Pagham Parish Council considered the following applications at a meeting of its Planning Committee Advisory Group. Comments are submitted by the Clerk on behalf of the Council in accordance with a scheme of delegation dated 4th May 2021.

P/140/21/HH – 6 Lion Road Pagham PO21 3JZ – detached annexe

PROPOSED DETACHED ANNEXE AT 6, LION ROAD, PAGHAM FOR MRS. A. ELSON

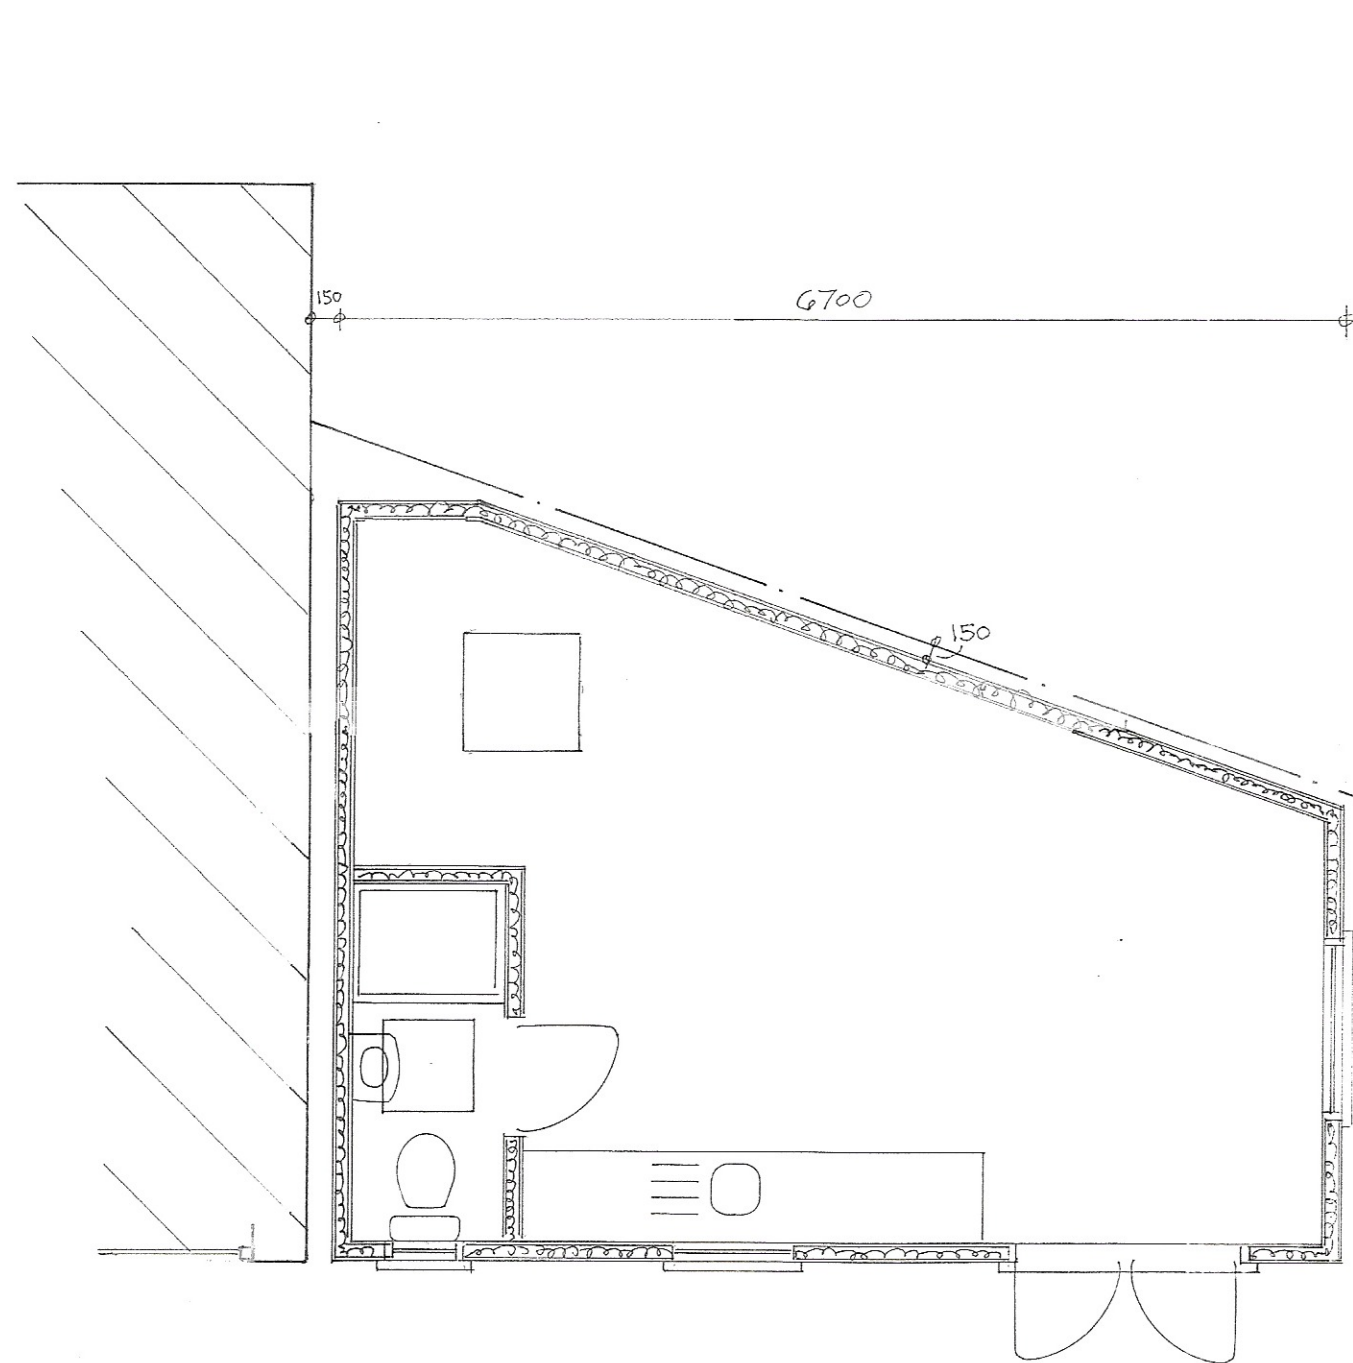
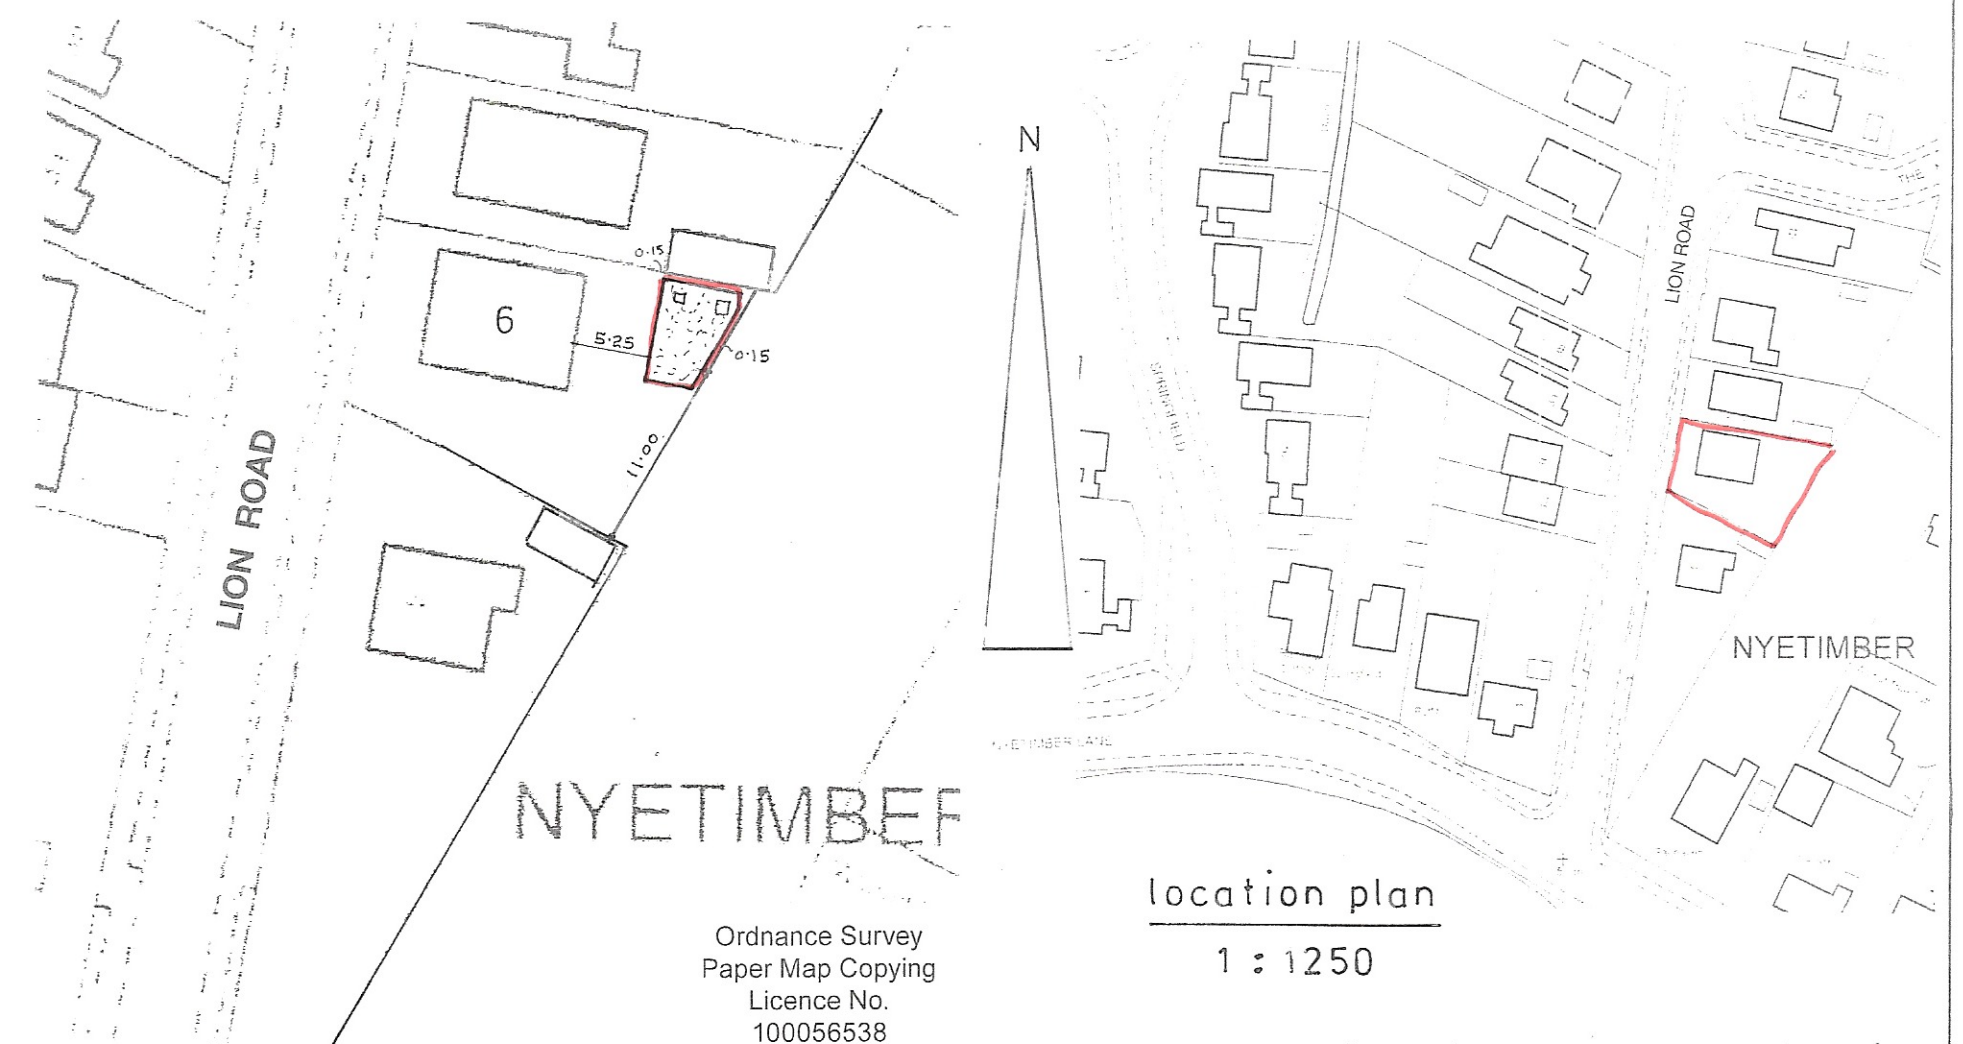
RESOLVED: the Council did not wish to formally object to this scheme but were concerned that the structure was being built abutting the boundary to the neighbouring property. It also had concerns that the purpose of the annex was not stated in the application.
